**PLANNING DEPARTMENT
DEVELOPMENT SERVICES DIVISION
600 2nd Street NW, Ground Floor, 87102
P.O. Box 1293, Albuquerque, NM 87103
Office (505) 924-3946**

OFFICIAL NOTIFICATION OF DECISION

Project# PR-2021-005716
Application#
SD-2022-00077 PRELIMINARY/FINAL PLAT

For all or a portion of: **TRACT 93A3, MRGCD
MAP 40 zoned R-1A, located at 711 7TH ST
SW between STOVER AVE SW and
ATLANTIC AVE SW** containing approximately
0.2585 acre(s). (K-14)

**Plat for  
 Tracts 93A3-A, 93A3-B,  
 and 93A3-C  
 MRGCD Map 40  
 Being Comprised of  
 Tract 93A3 MRGCD Map 40 and  
 an Unplatted Parcel  
 City of Albuquerque, Bernalillo County, New Mexico  
 March 2022**

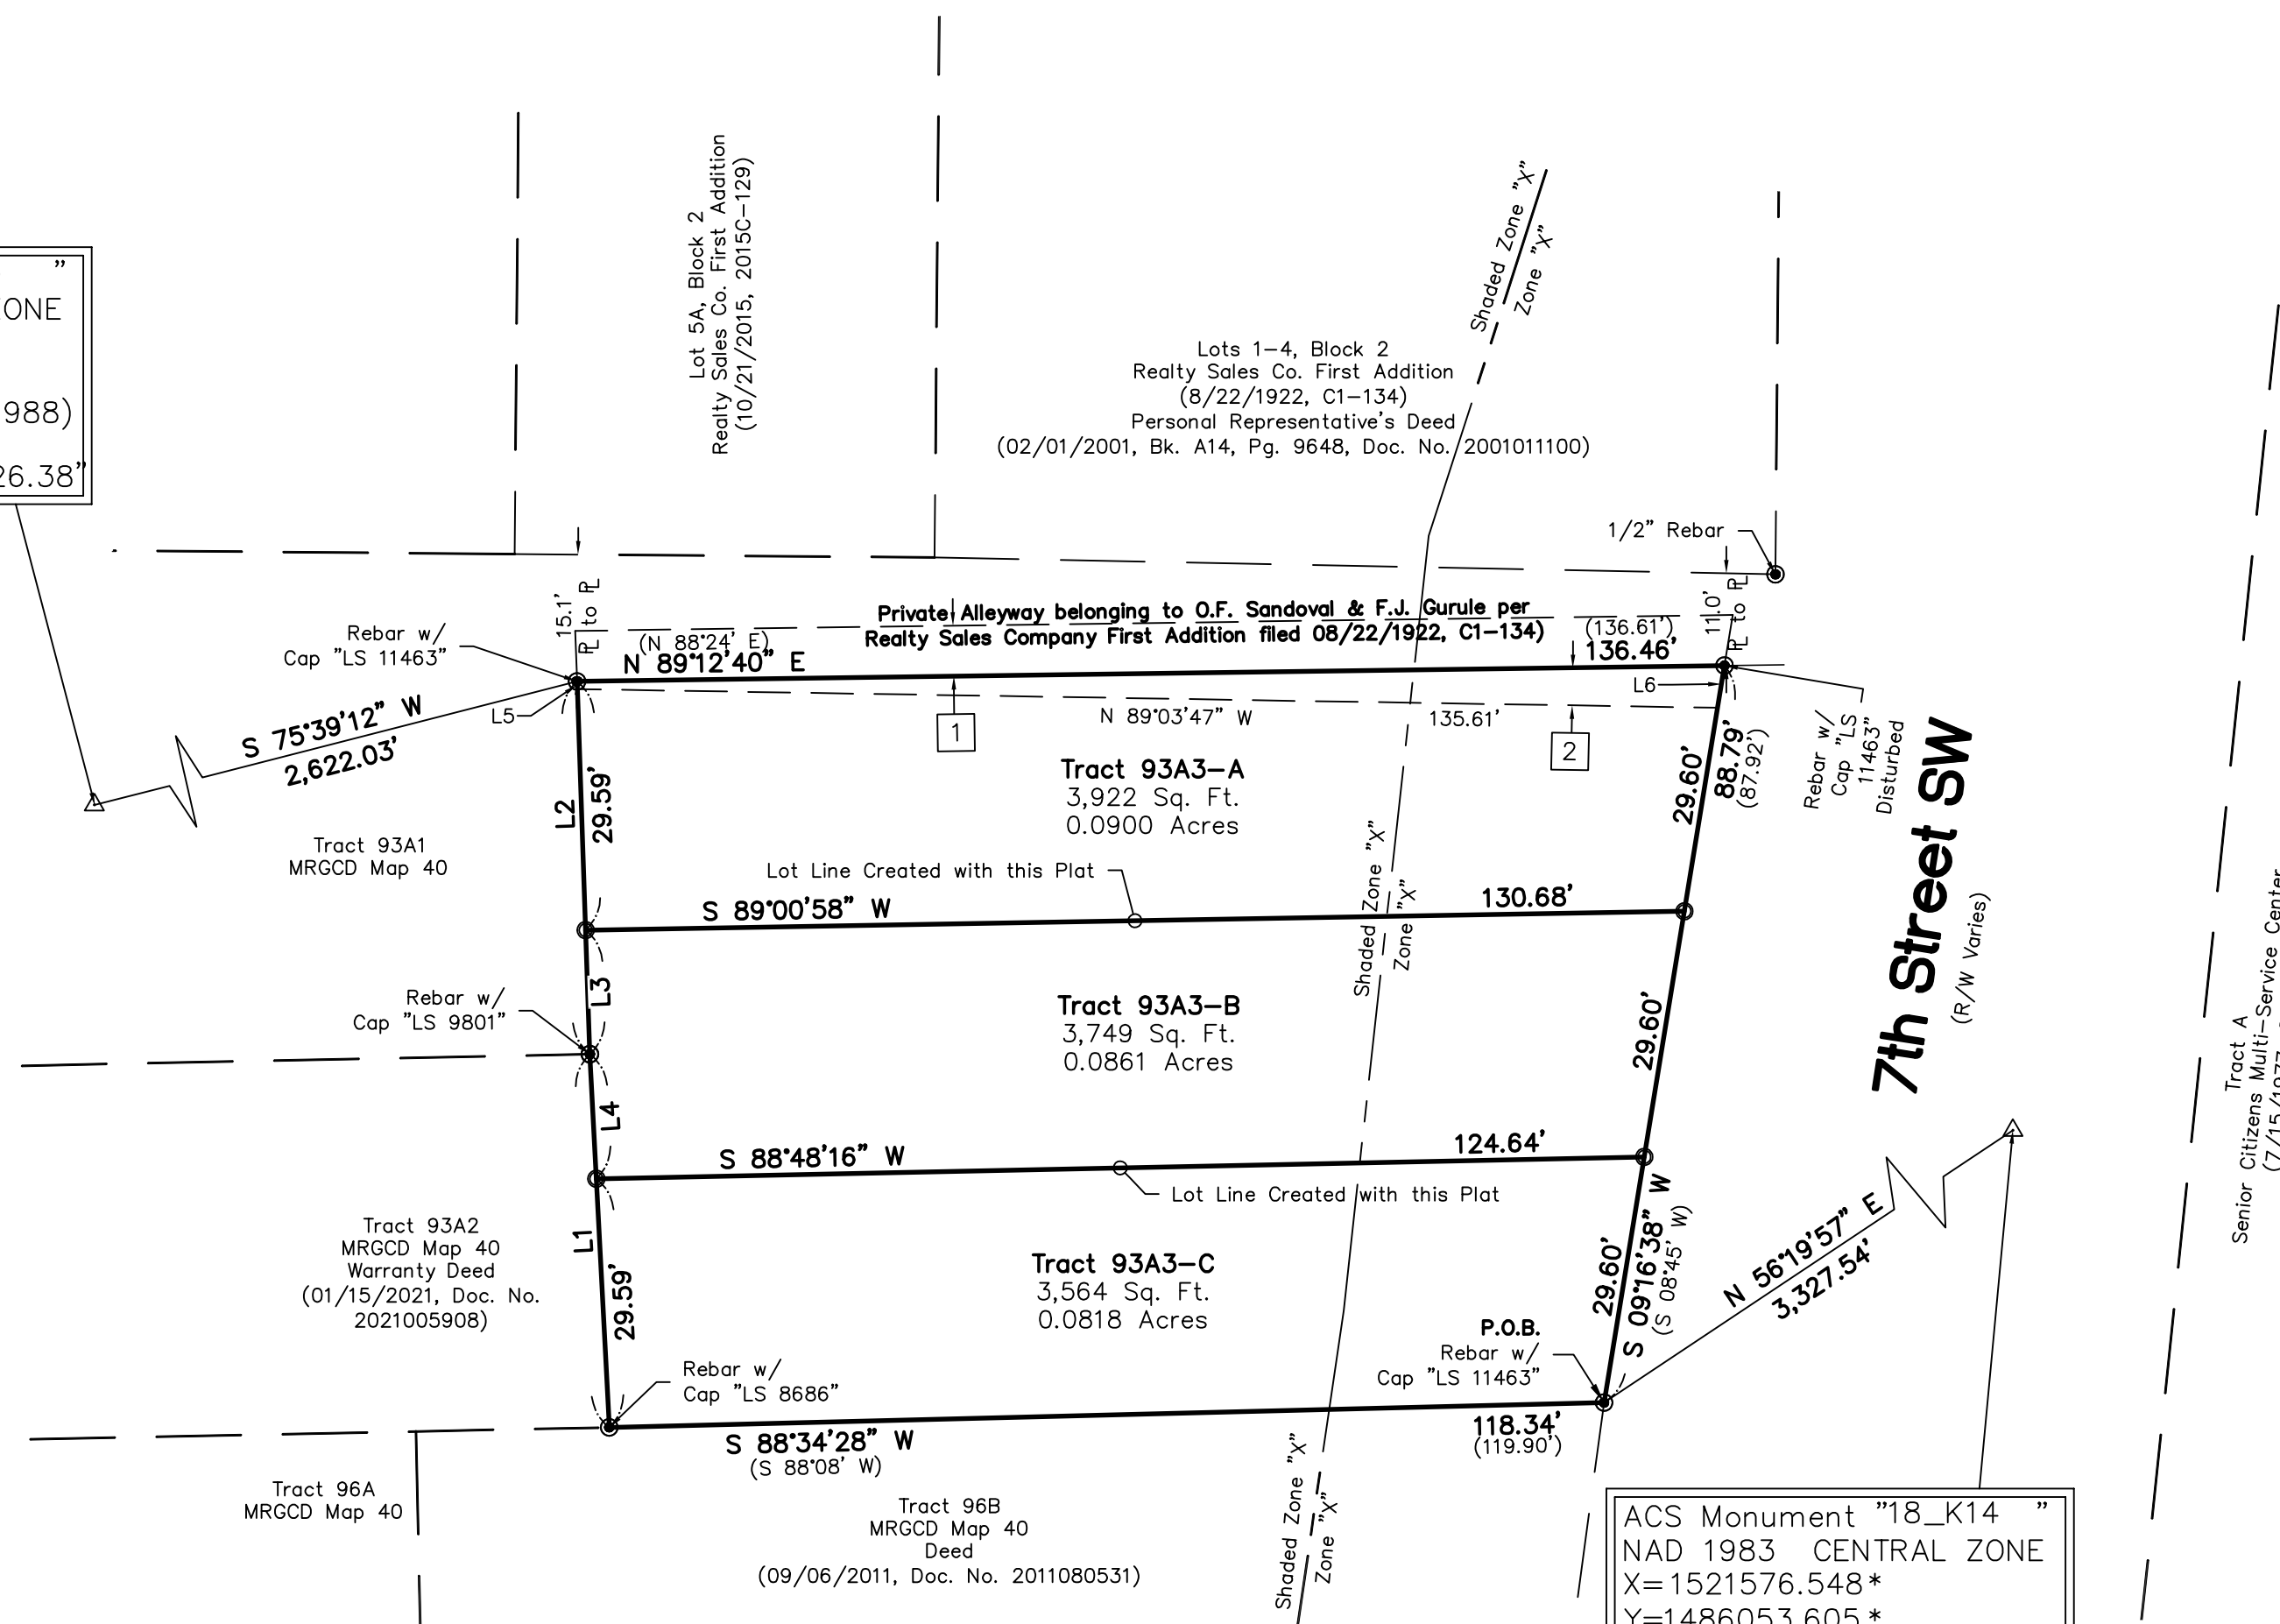
1. Final sign-off is delegated to Planning for the dates to be added to the easement notes and to the DRB Determination on the Plat.
2. The applicant will obtain final sign off from Planning by August 17, 2022 or the case may be scheduled for the next DRB hearing and could be denied per the DRB Rules of Procedure.
